EPBC Ref: 2013/7028

Comment on Environmental Impact Statement for the Proposed Expansion of Tinda Creek Sand Quarry, Putty Road, NSW

Mahani Taylor
Director
NSW Section
2 September 2014

Figure 2 – Modelled Final Landform Domain 7 Extraction

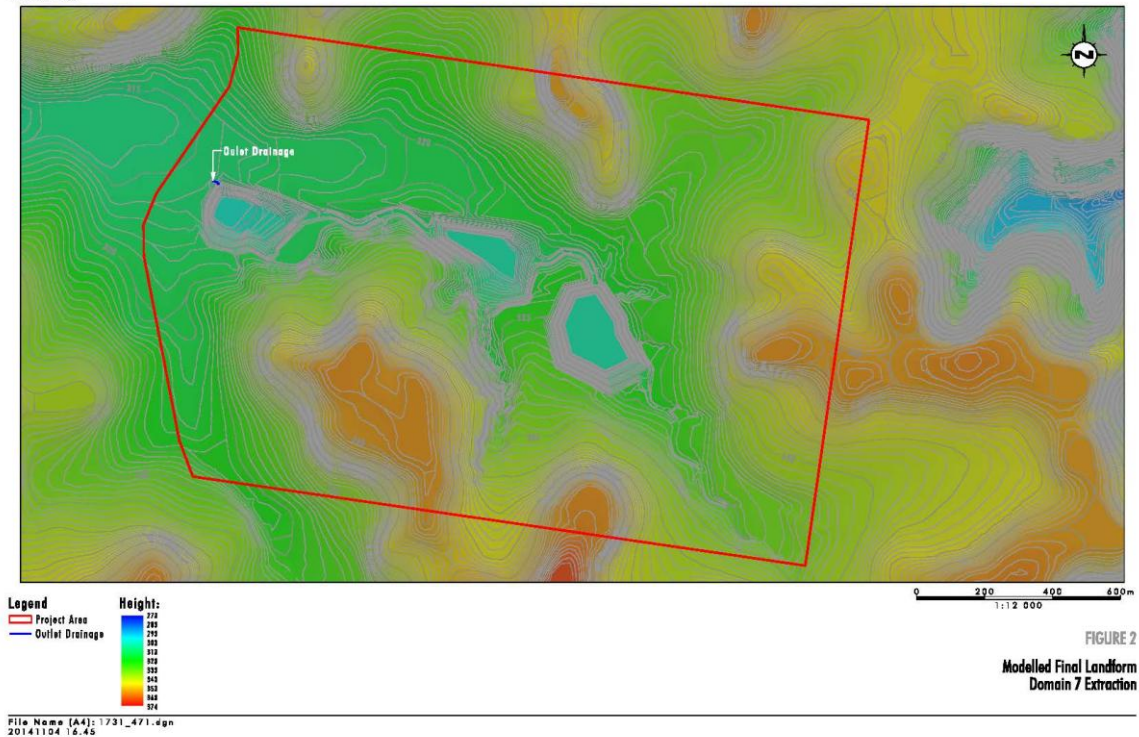
2. The Department requests that information be provided on how the watercourse diversions will be designed to maintain downstream water quality, particularly how erosion from the diversions will be minimised.

FIGURE 6

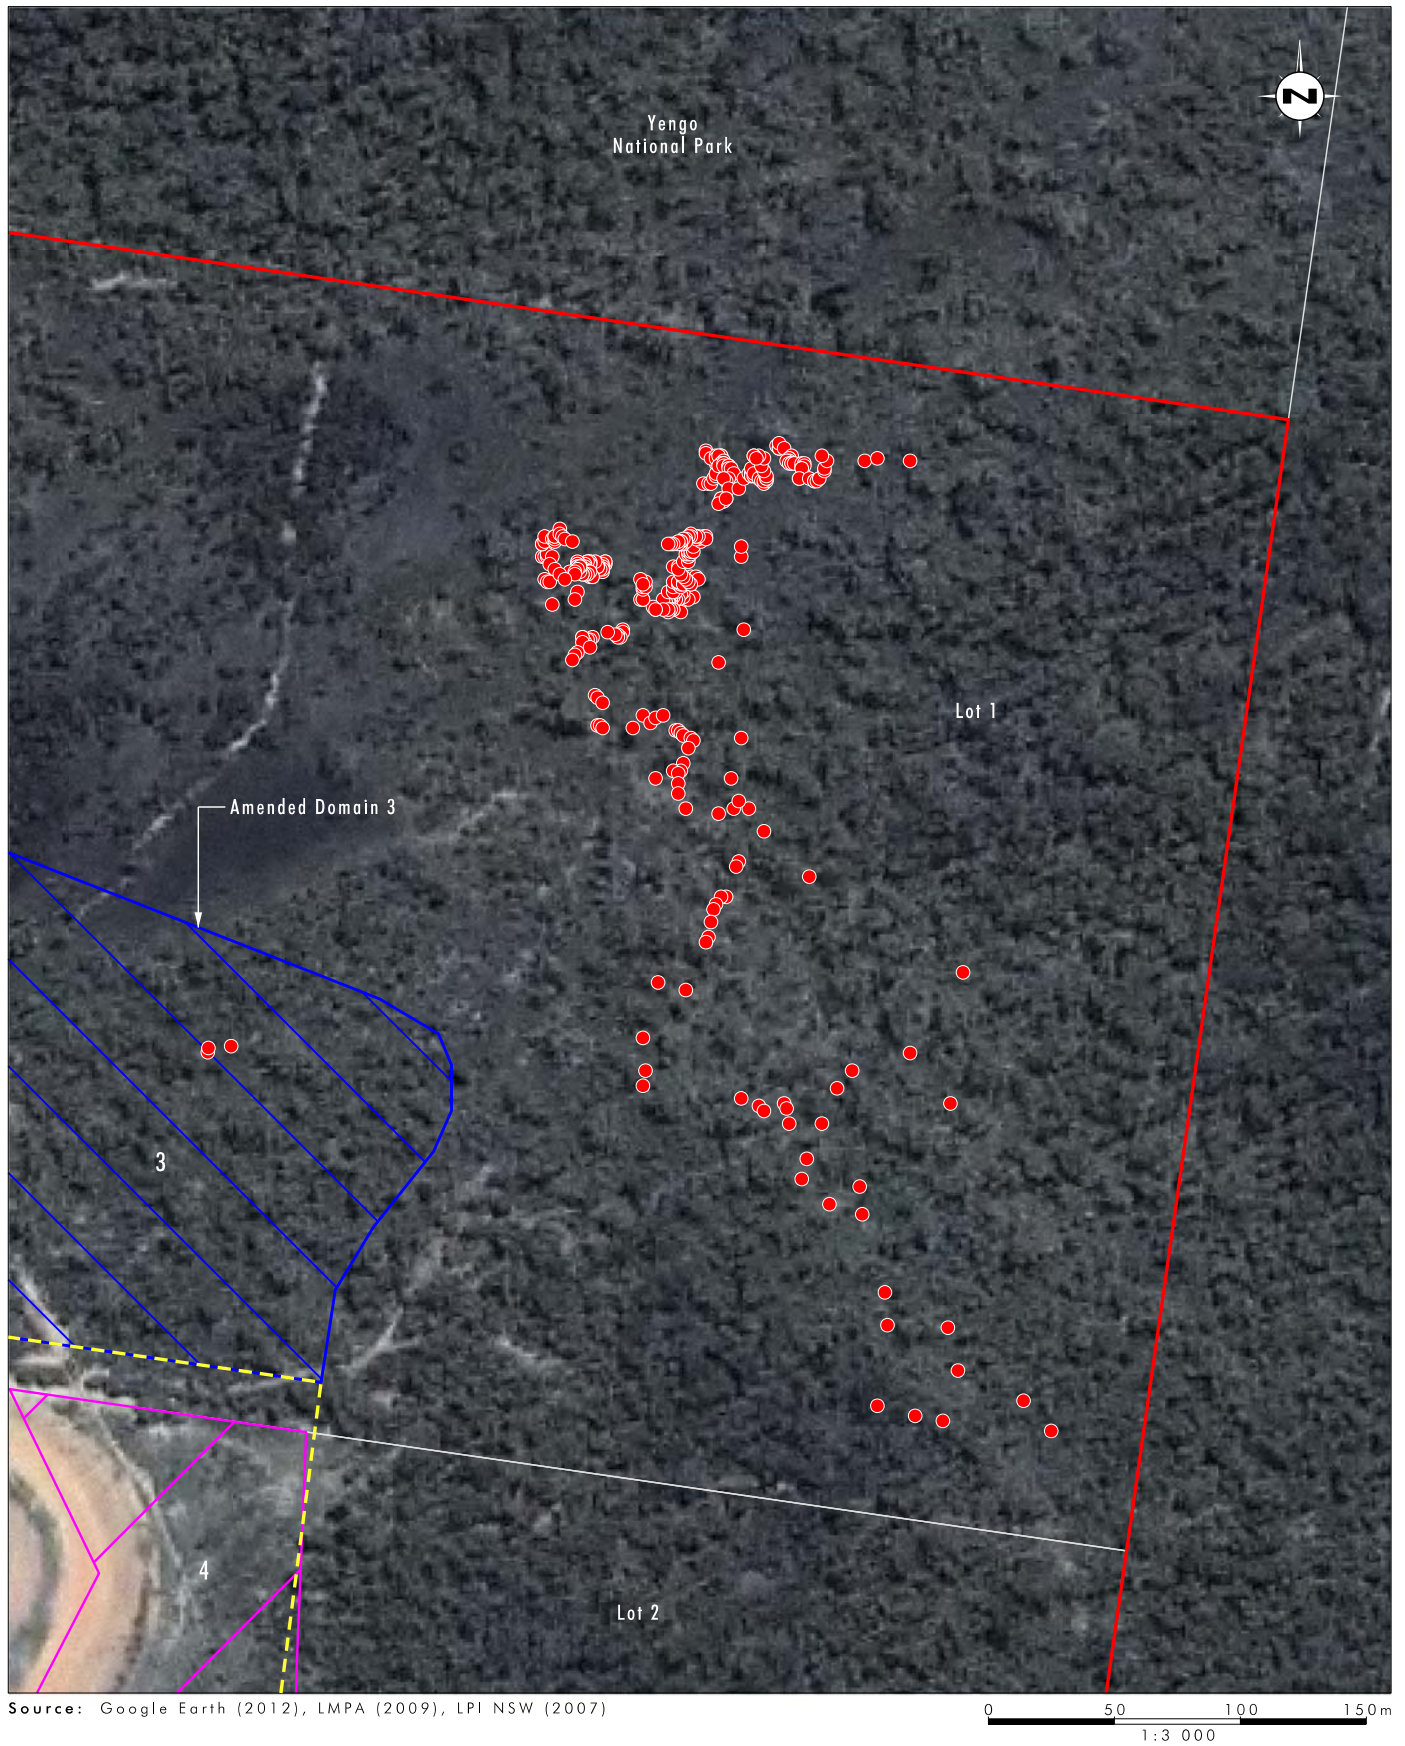
5. The domain 7 option provides for a ten metre buffer zone between the quarry and the proposed offsets area (see p7.9 of EIS Appendix 7). The Department requests further information be provided demonstrating that this would be effective in avoiding indirect impacts to *Grevillea parviflora* beyond the buffer. This should include information on how the buffer will be managed for ecological benefit and the activities and access that will be allowed in the buffer.

Grevillea parviflora subsp. *parviflora*
Proximate to Domain 3

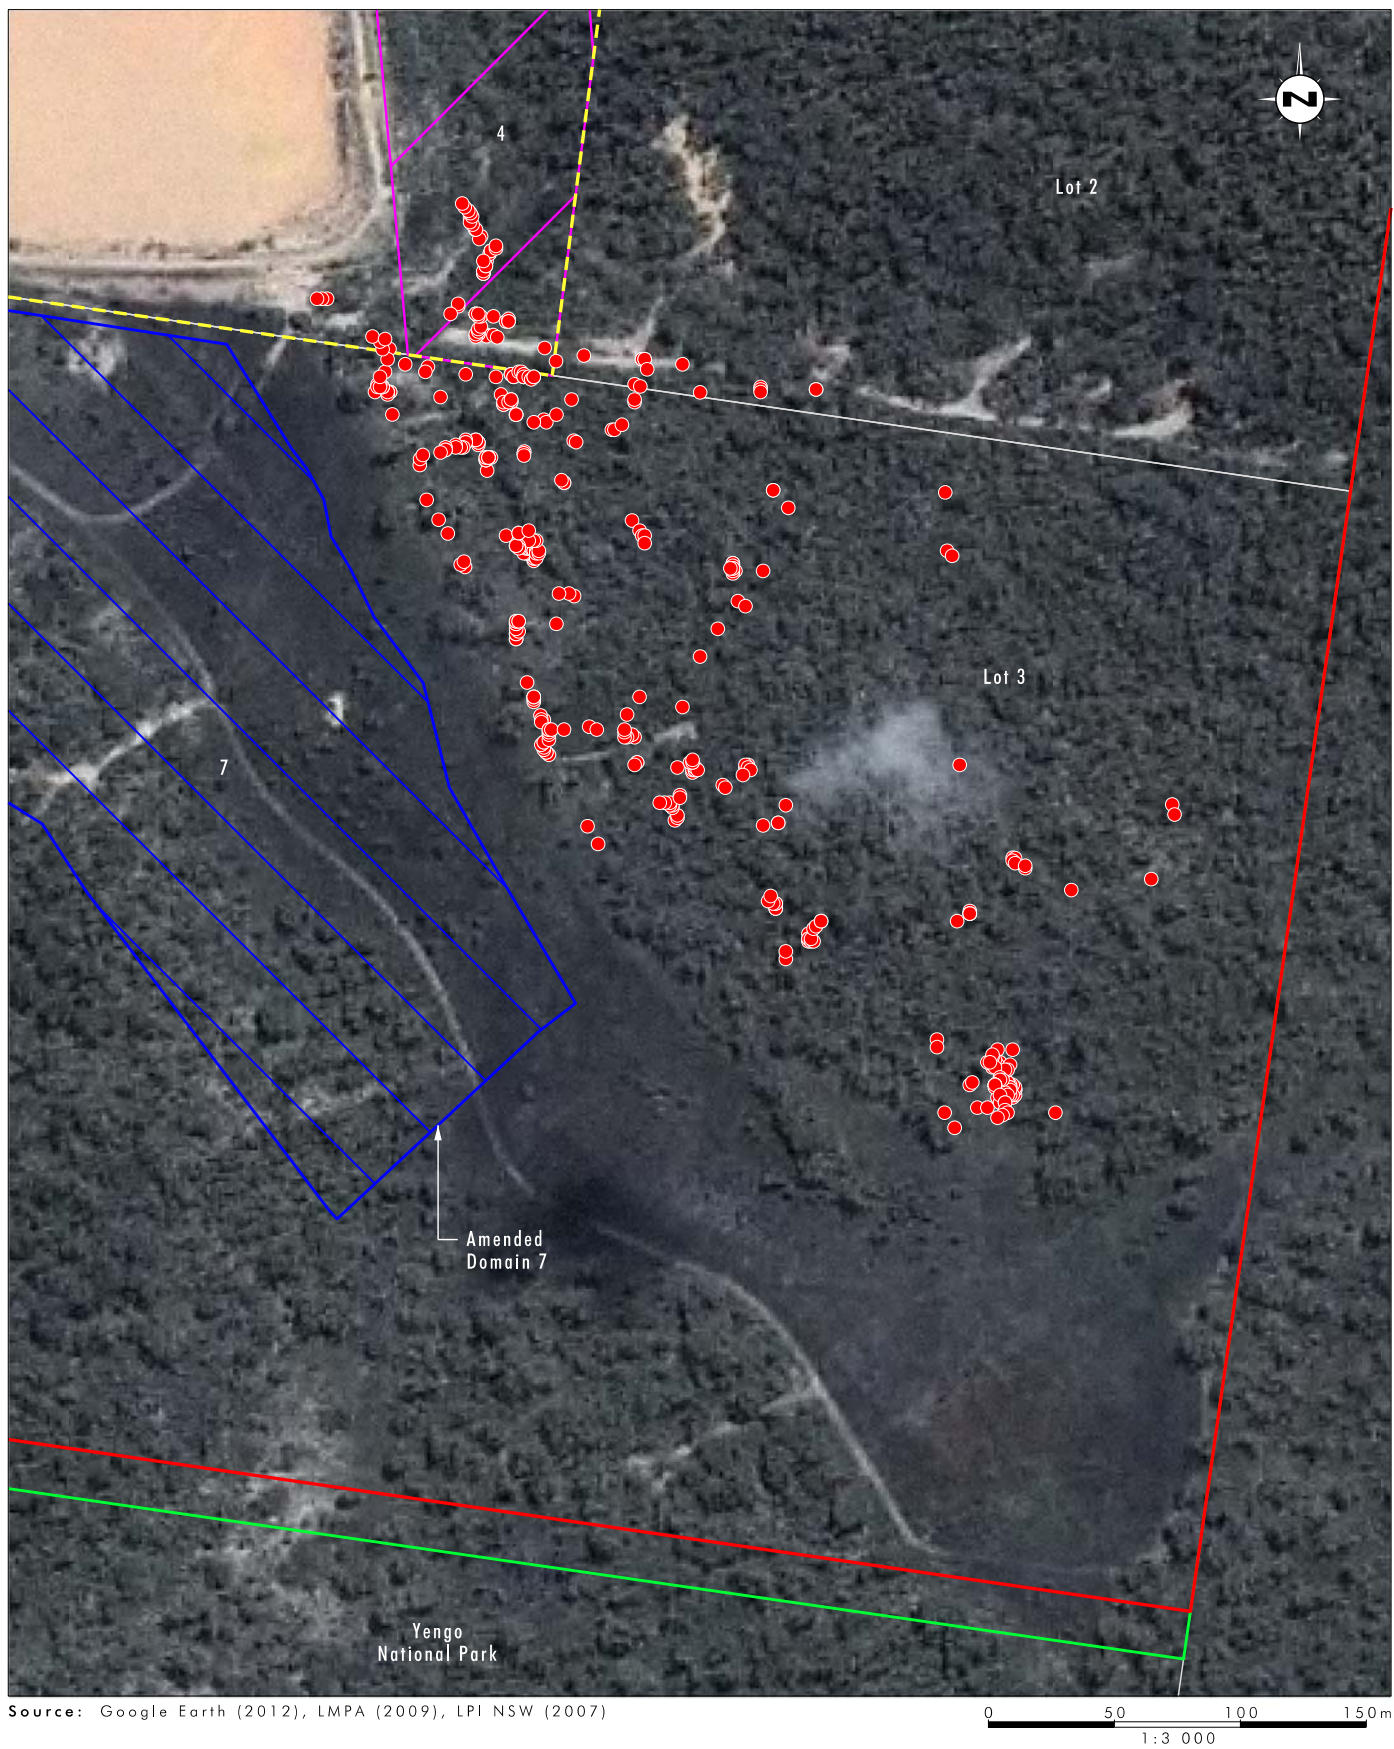
- a. the proximity of individuals to existing quarrying activity (While this information has been presented graphically (Figure 4.2 of Ecological Assessment), it is difficult to judge the distance precisely. A higher resolution map is requested, together with a text description.

- b. the distance between quarrying activities and individuals proposed if domain 3 is quarried
 - c. any additional information that would aid in assessing indirect impacts on the species.
